From: Polly Harris-Gorf
Sent: 07 January 2021 15:05
To: _planningadvice <planningadvice@sholland.gov.uk>
Subject: AMENDMENT 1 - J1930 LAND TO REAR 12 MARKET PLACE, DONNINGTON - H04-0879-20

Polly
Happy New Year. As discussed prior to the Christmas break please find attached the revised package of drawings and documents for the above reserved matters application. As considered during our Teams meeting we have amended the application as follows:

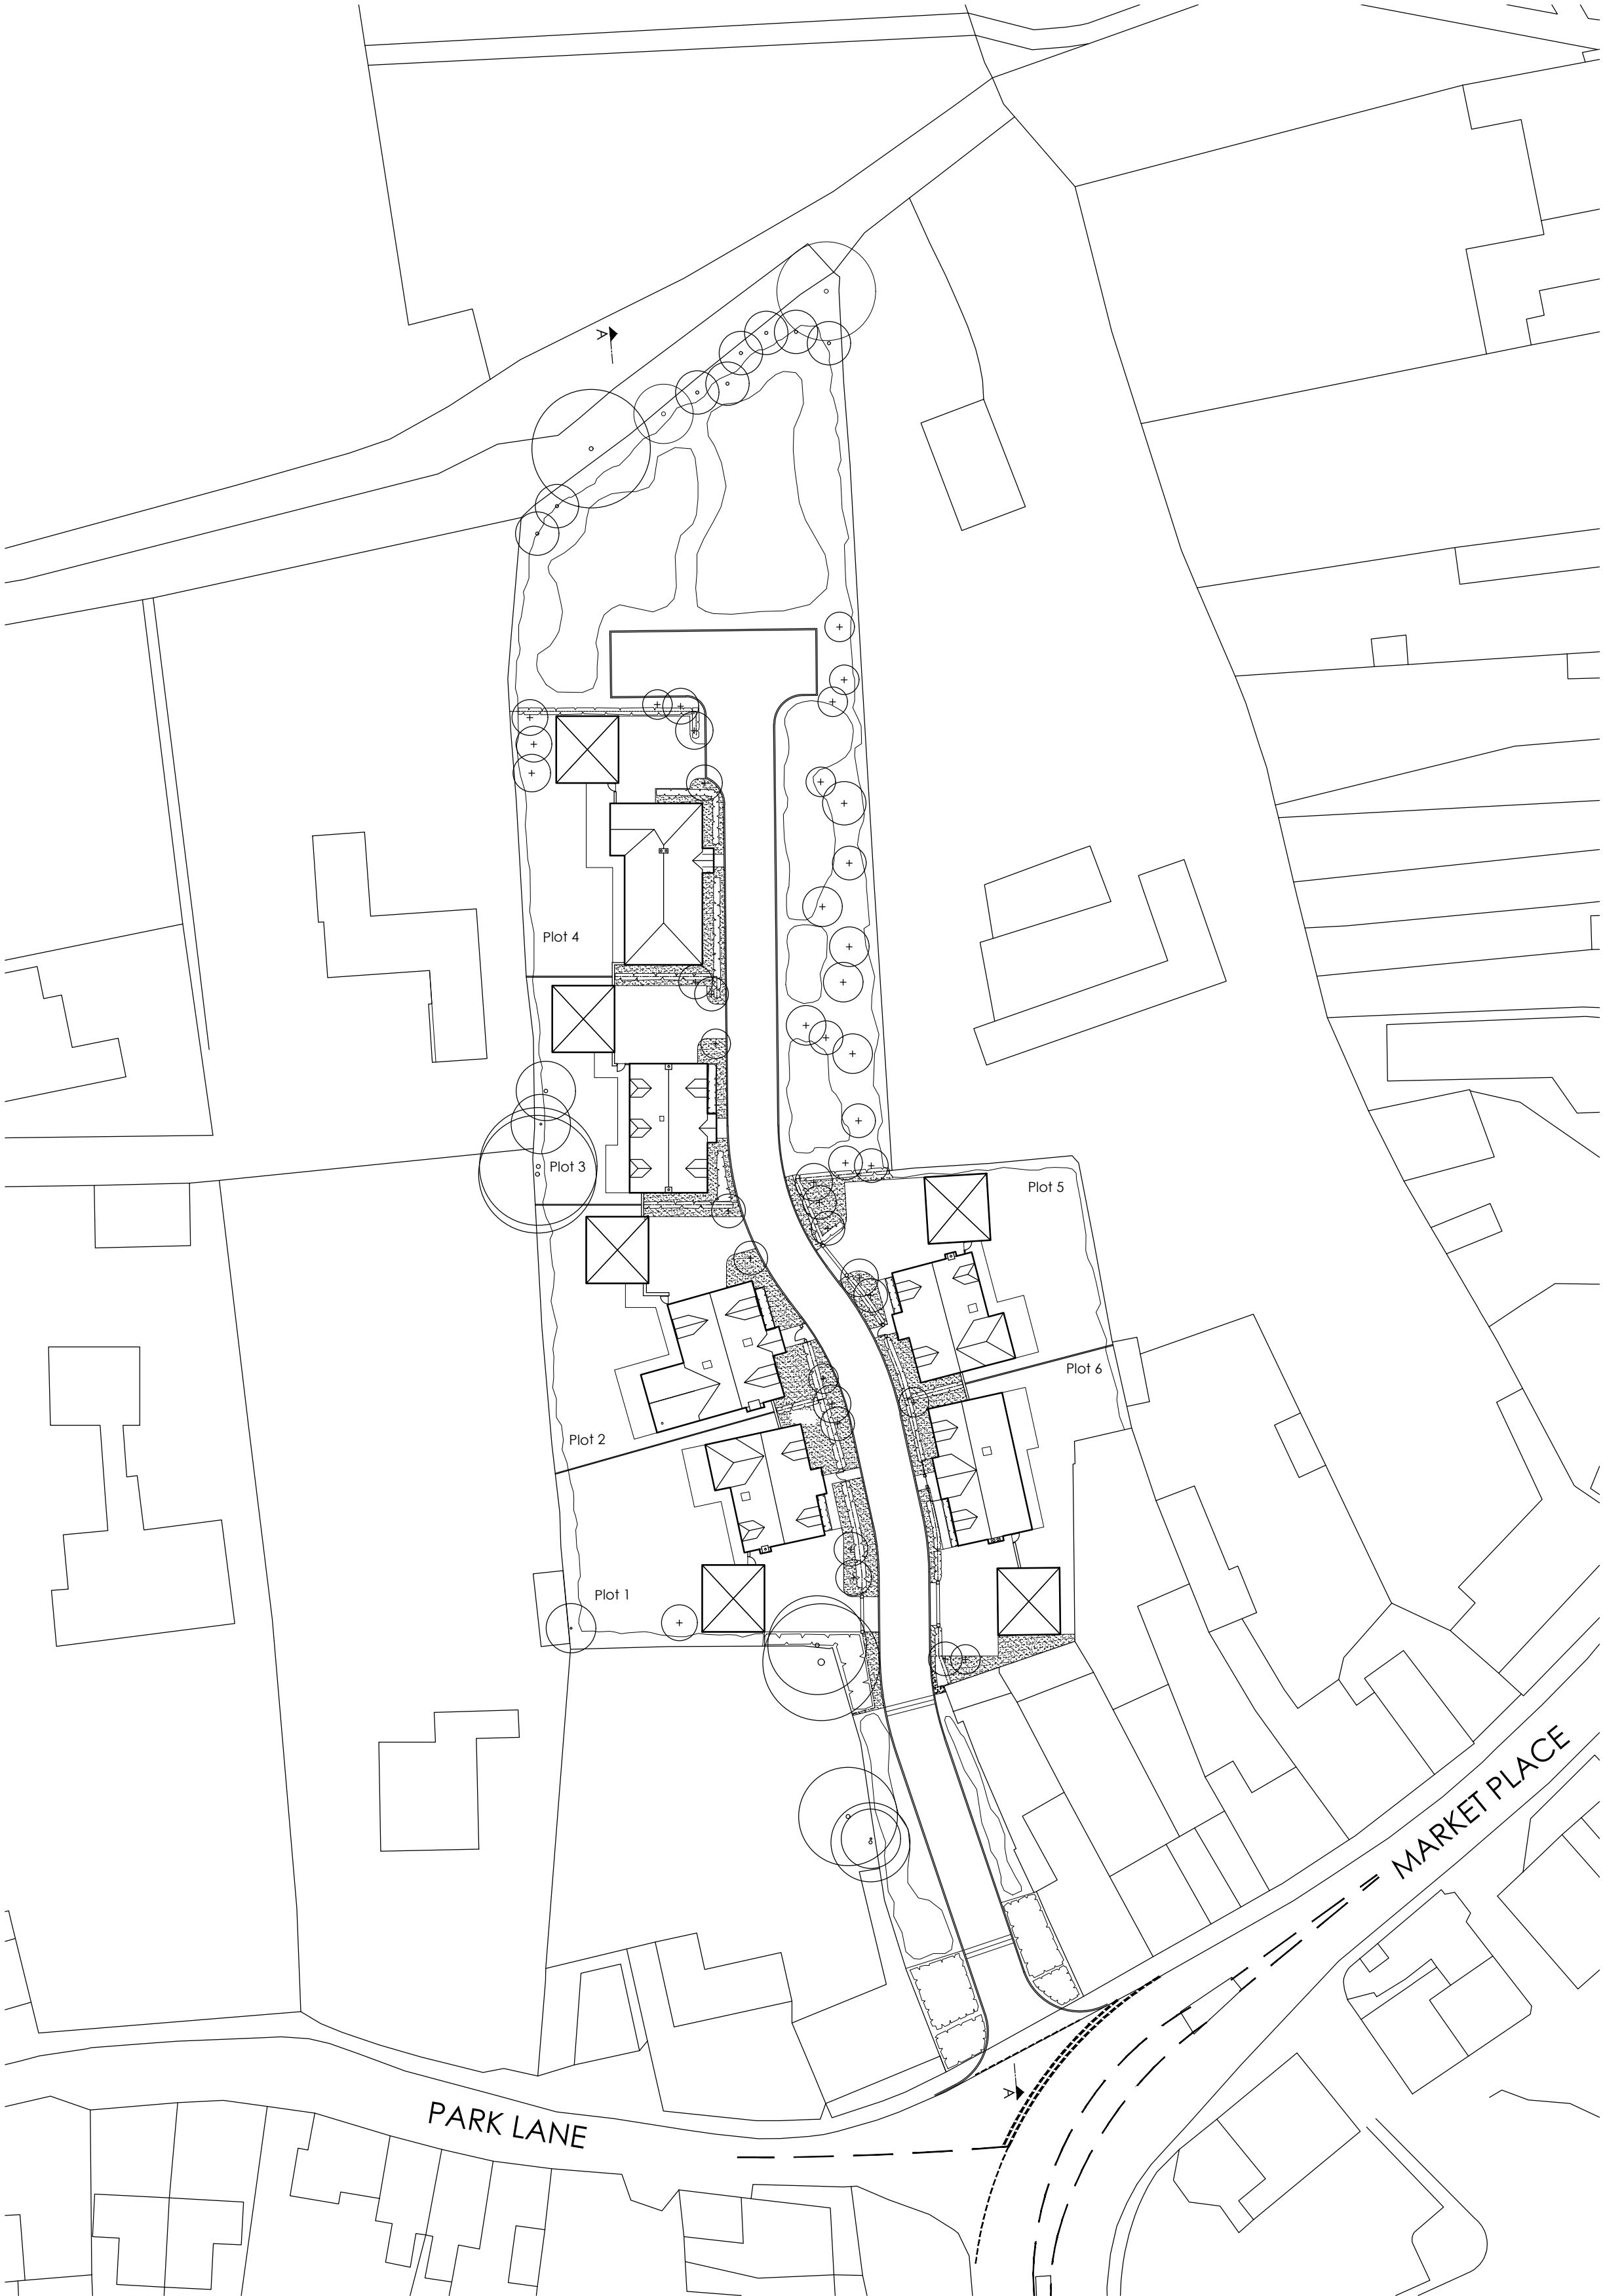
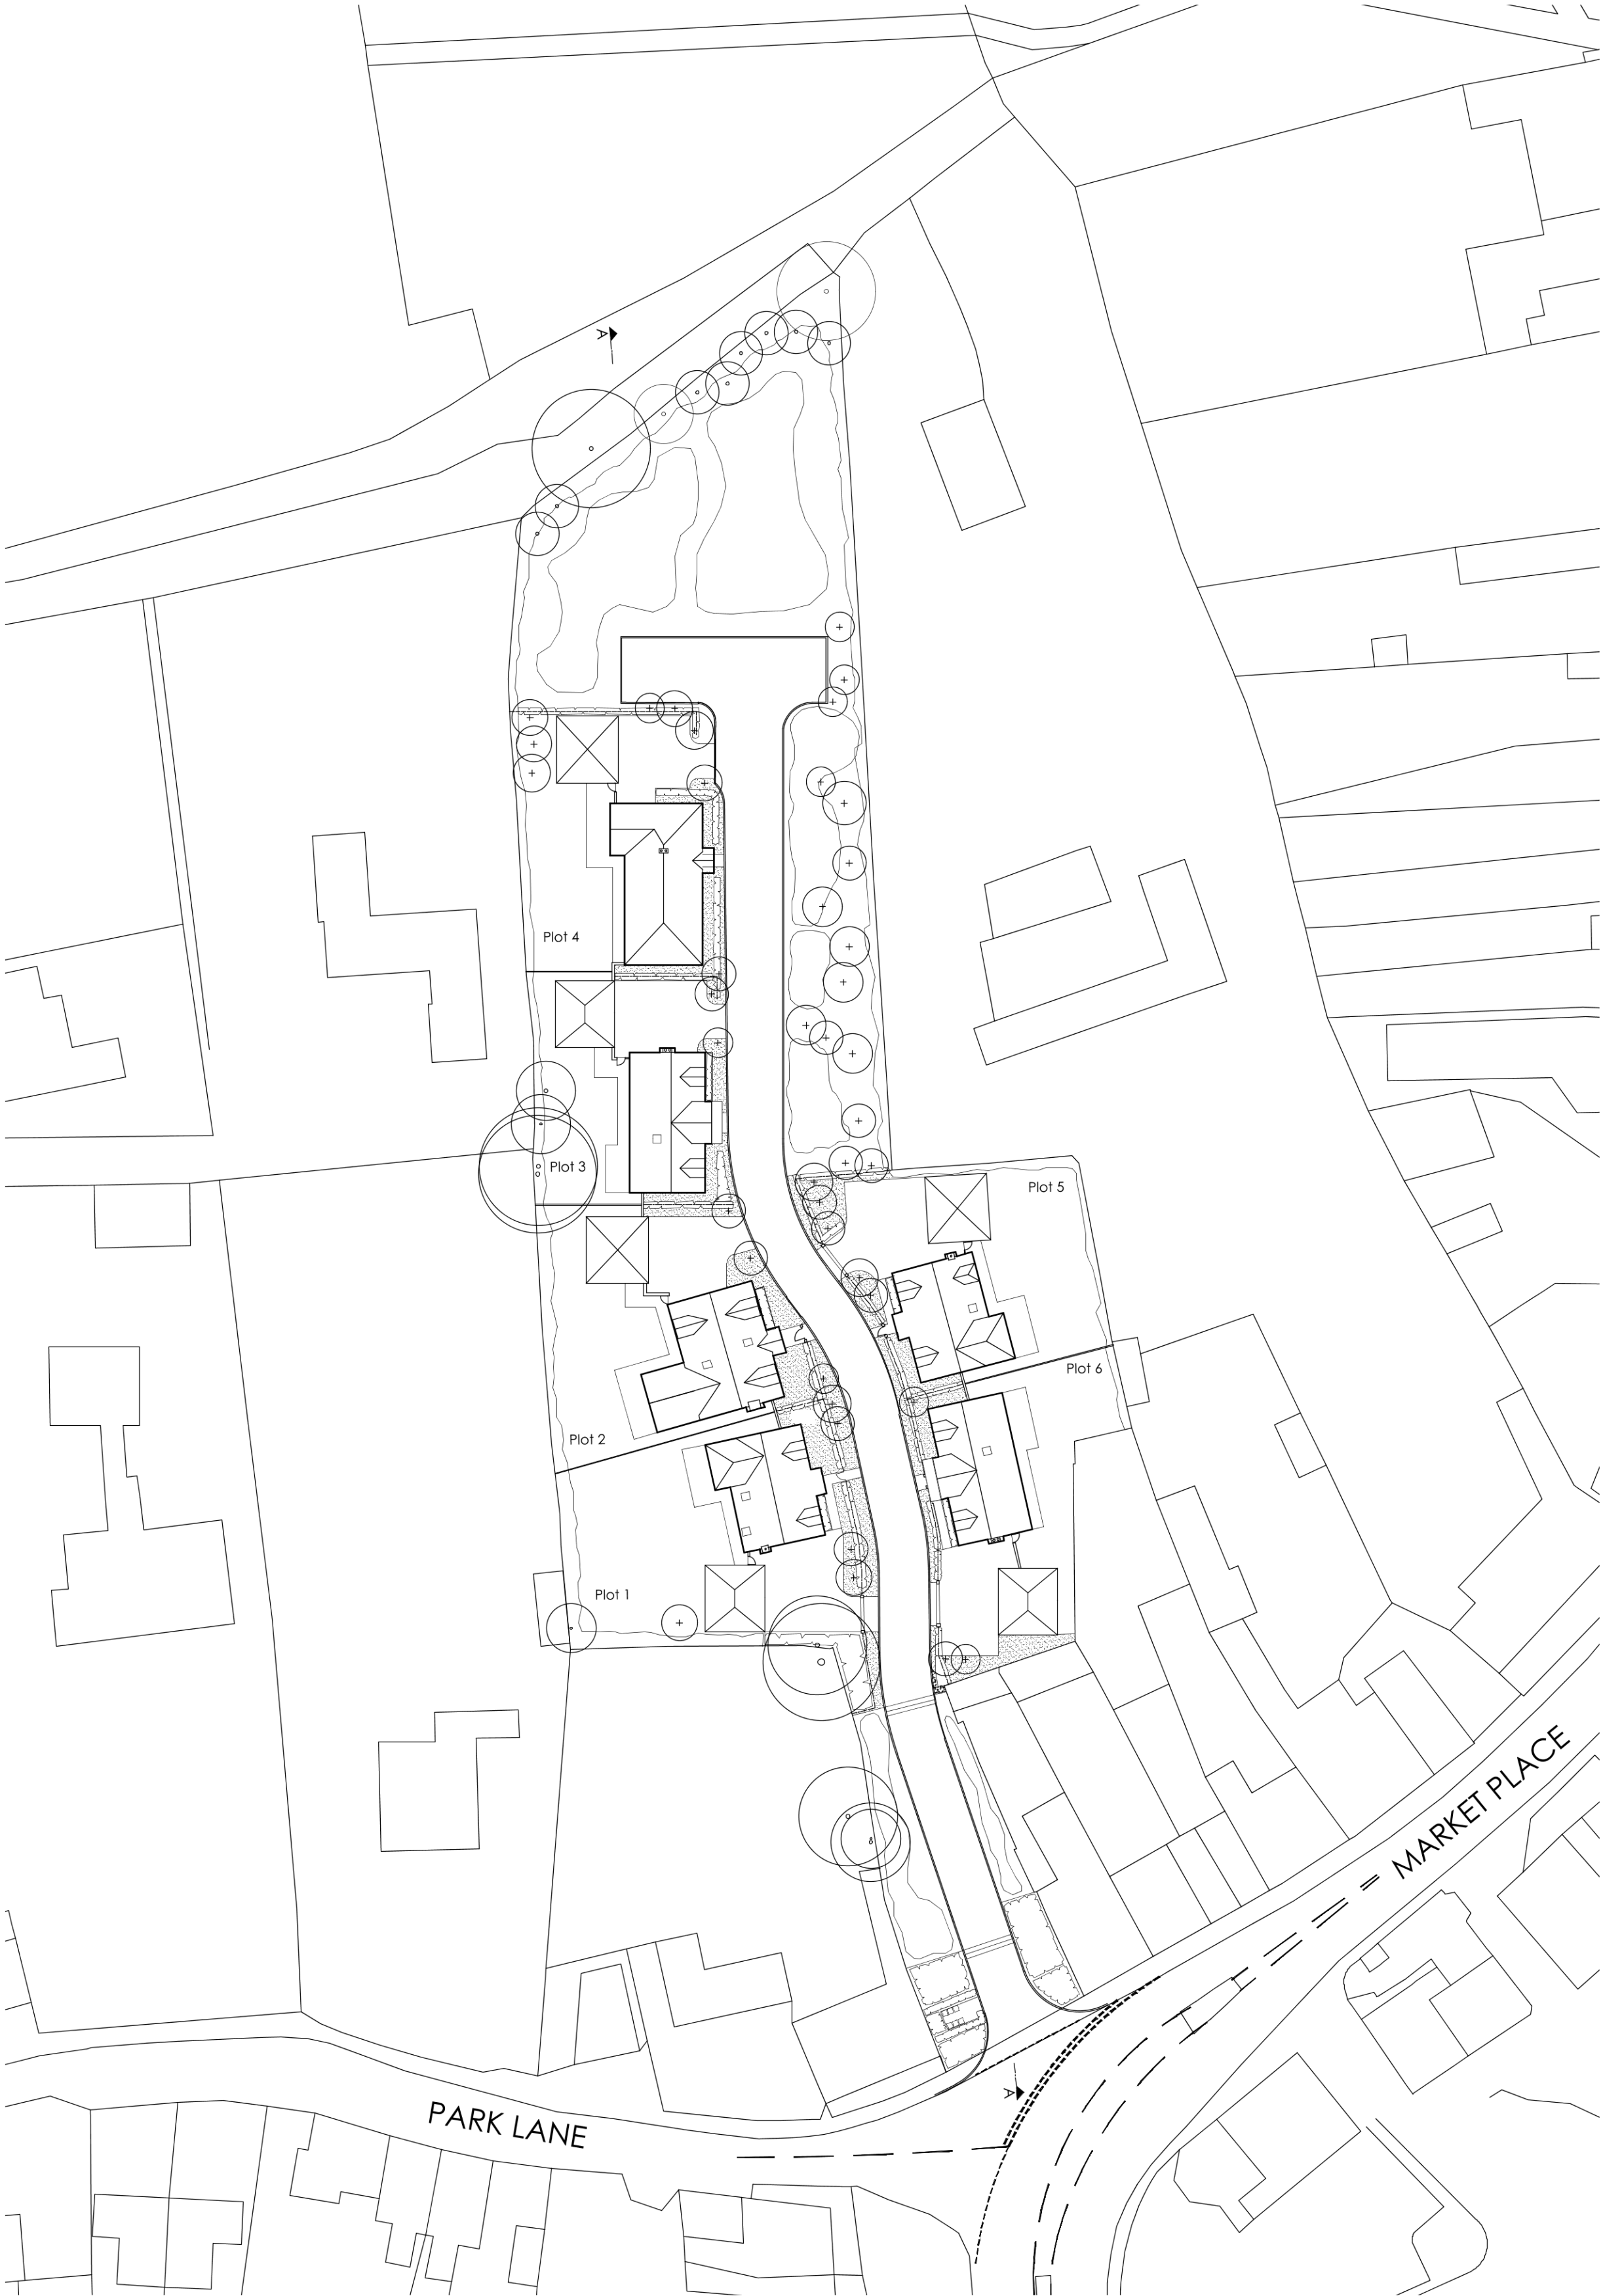
The proposed site plan, block/roof plan, site levels plan, landscape planting plan and plant schedule have all been revised in-line with the above updates. We also discussed the timeframe for the application and you mentioned you would be in a position to present a recommendation to approve at the Chairman's panel on the 22nd January and issue a decision on the 26th January 2021. We look forward to receiving confirmation this and receipt of the attached information. Trust the above is clear, any questions please call.
